The Planning Inspectorate

Our Ref: EN010060

Date: 07 March 2014

Further to our meeting on 21 February 2014 and on the basis of the draft documents provided to us, please see our comments attached. The comments are without prejudice to any decision made under section 55 of the Planning Act 2008 (as amended) or by the Secretary of State on any submitted application.

Title:  
 Progress Power Limited - Works Plans Figure 1 (Sheet 1 of 2)  
 GIS Variant Only  
 The Infrastructure Planning (Applications: Prescribed Forms and Procedure) Regulations 2009  
 Regulation r5(2)(g) Document Reference: 2.7

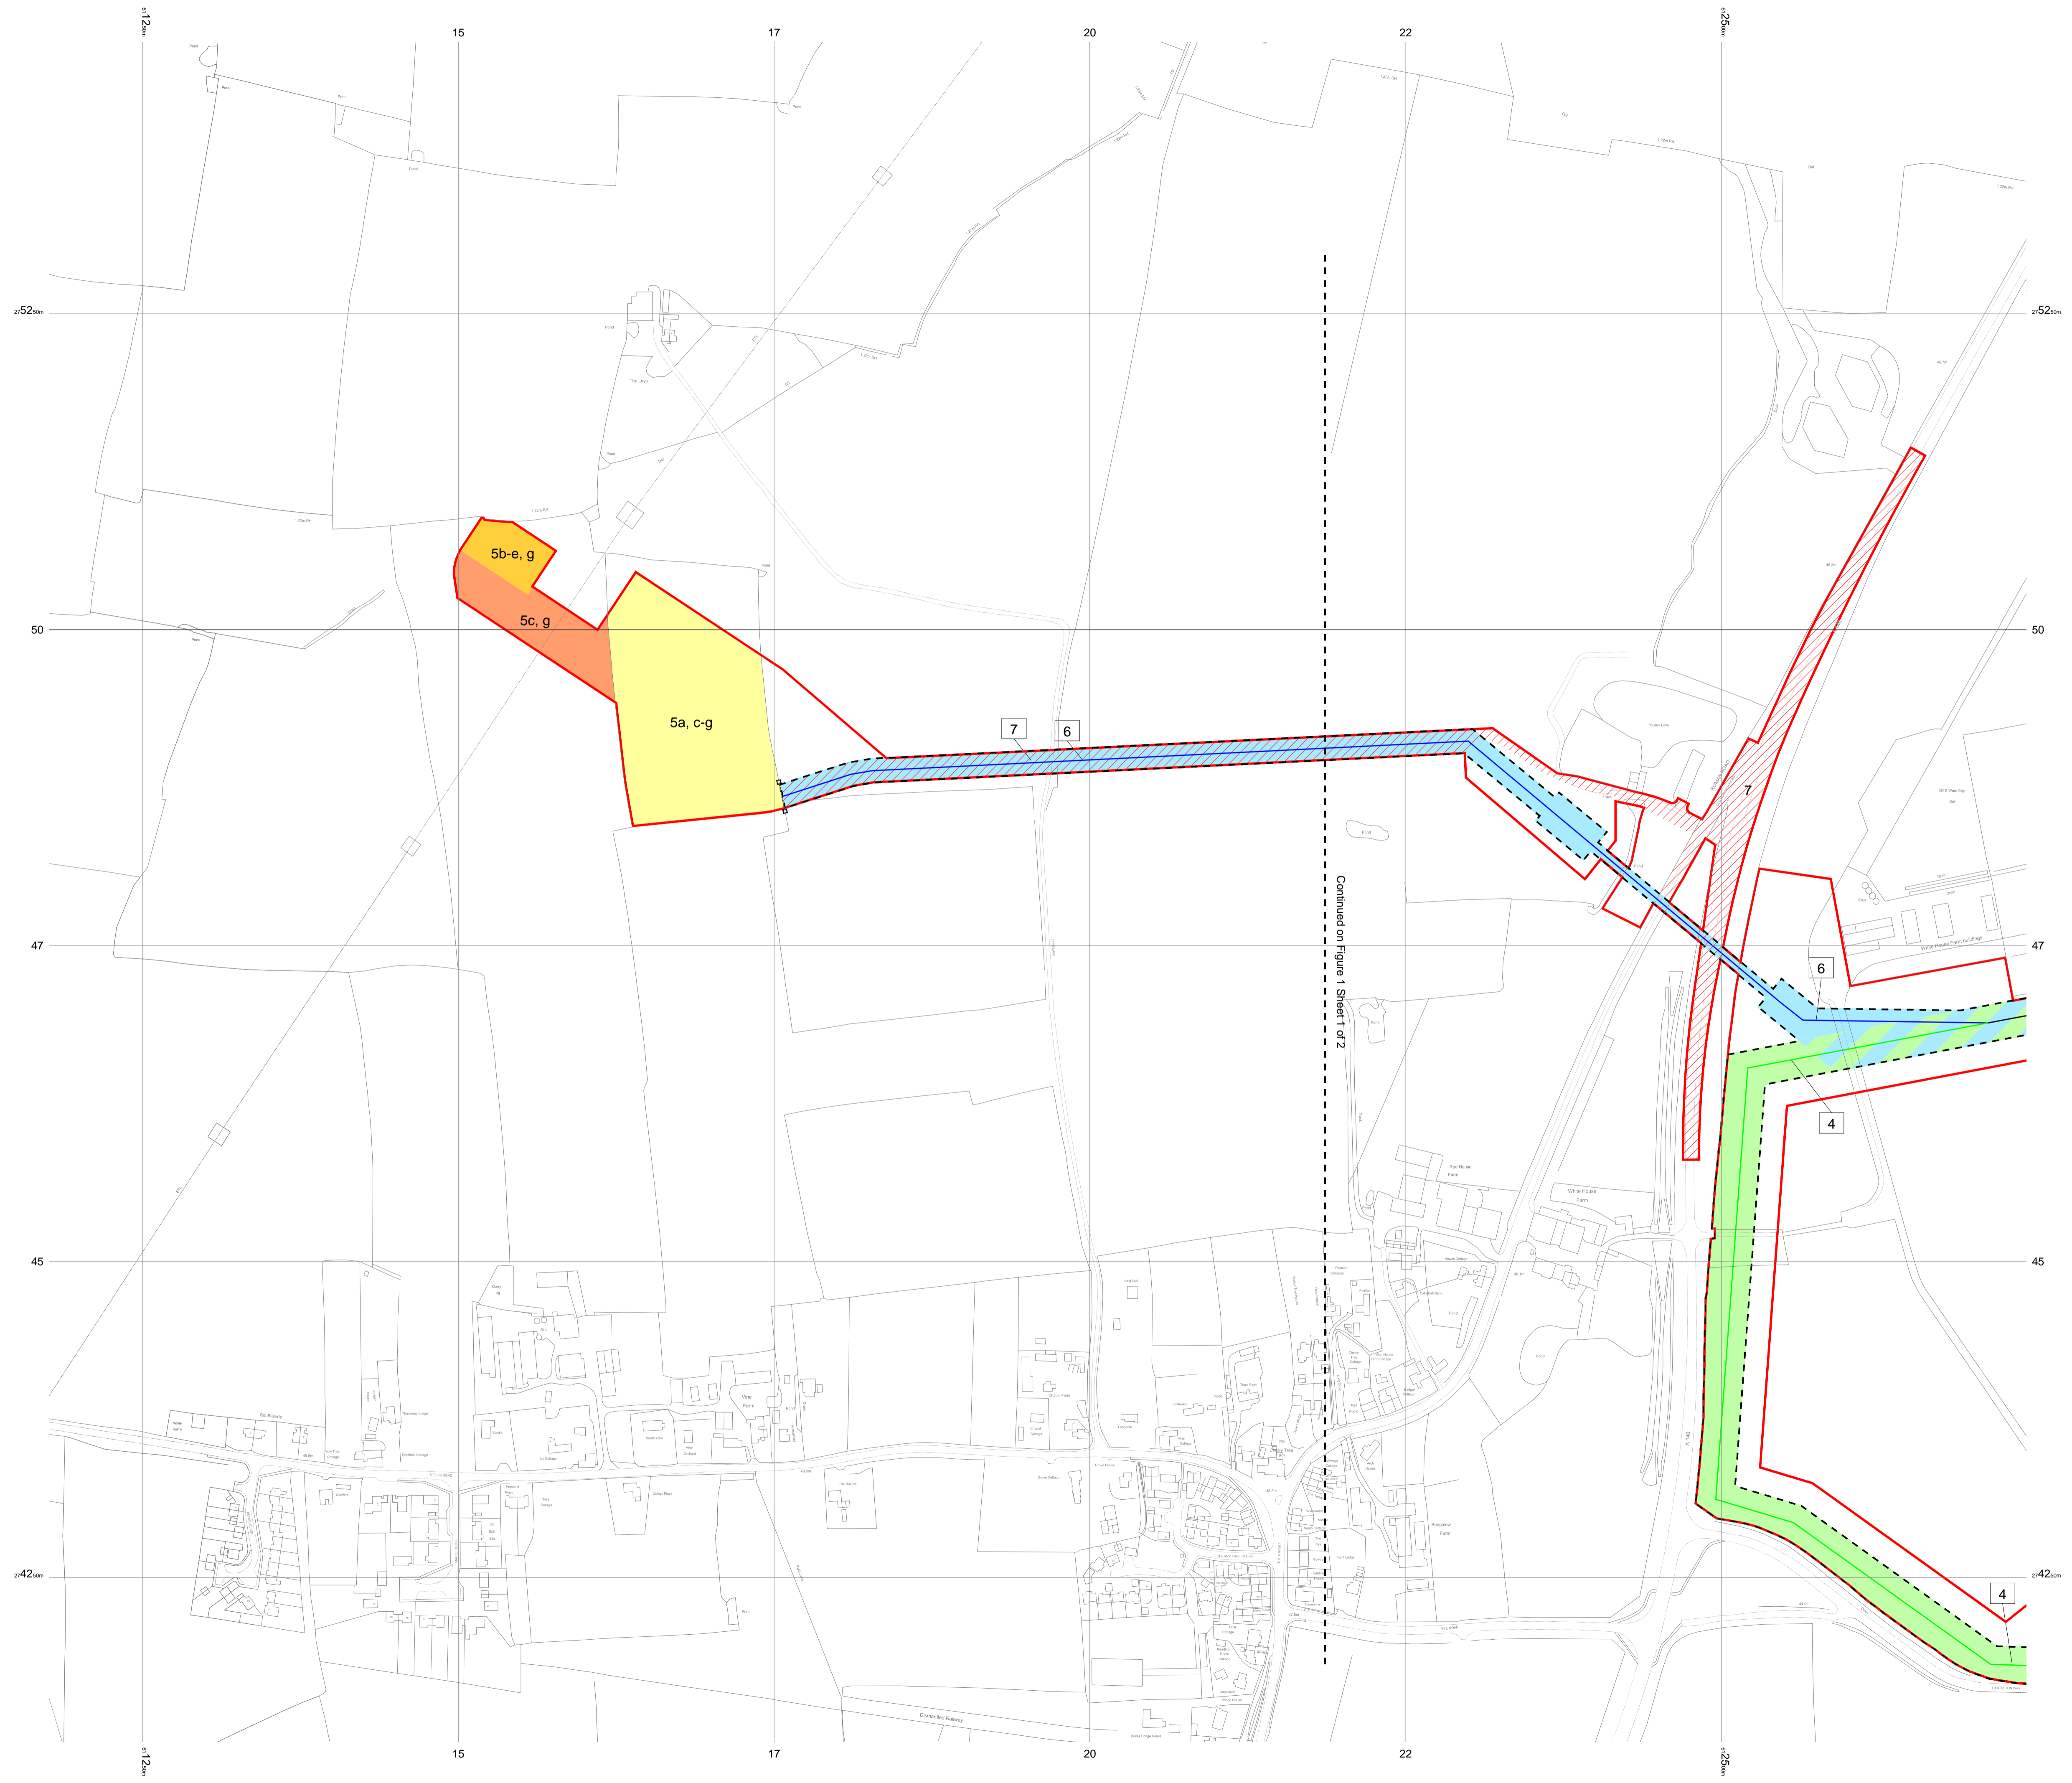
- 1.1 In general, the plans appear clear at this stage subject to the clarifications below.
- 1.2 The cross hatching technique, used to illustrate Works 3A and 3B on Works Plan Fig 2 (sheet 1) may appear confusing given the use of black and white colour. The plans may benefit from being coloured, to aid in differentiating between the two works.

- 1.3 Works no. 7 (site access) does not appear to be labelled on both sheets of Works Plan Fig 2. This is also applicable to Works no. 5.
- 1.4 The lines used to differentiate between the Order limits and the Limits of Deviation may benefit from being of different thicknesses to ensure clarity. Care should be taken when doing so however so as not to falsely describe the Limits of Deviation being applied for.
